Our ref: DOC21/110321

### **Notice of Exhibition of application for (Snowy 2.0 Transmission Connection) (SSI-9717)**

18 March 2021

**Figure 4-17** | Heritage items with archaeological potential

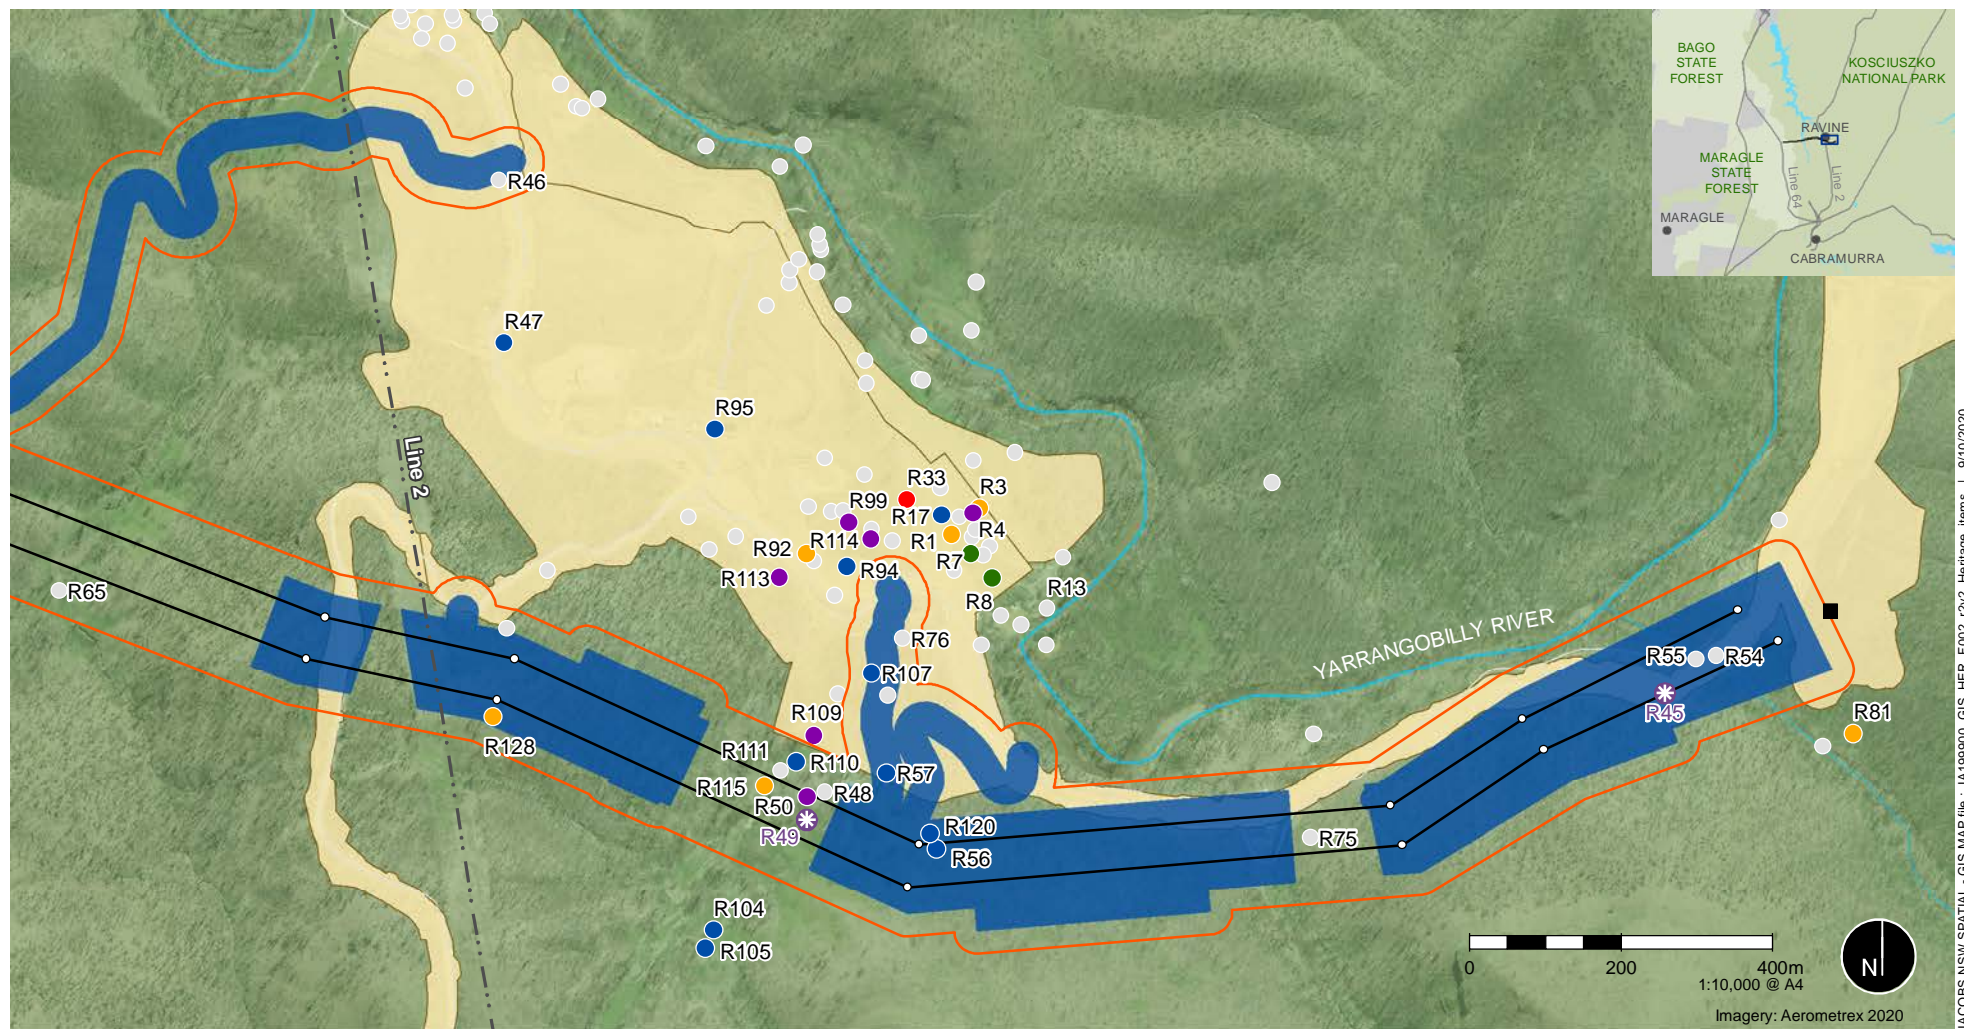
- Five items with historical archaeological potential will be subject to major disturbance from the project. Of these five items none were considered to have archaeological significance. Two of these archaeological items have been previously recorded. For the remaining three archaeological items the report recommends text excavation followed by salvage excavation if required. It is unclear why the proponent proposes to excavate areas with no archaeological significance. It is recommended that the report is updated to provide:

- A clear assessment of potential significance, including the contribution of the areas of archaeological potential to the wider Snowy Hydro scheme.
  - If the assessment of significance identifies that areas of archaeological significance will be impacted options to avoid these areas should be considered. If avoidance is not possible a research design and excavation method should be produced.
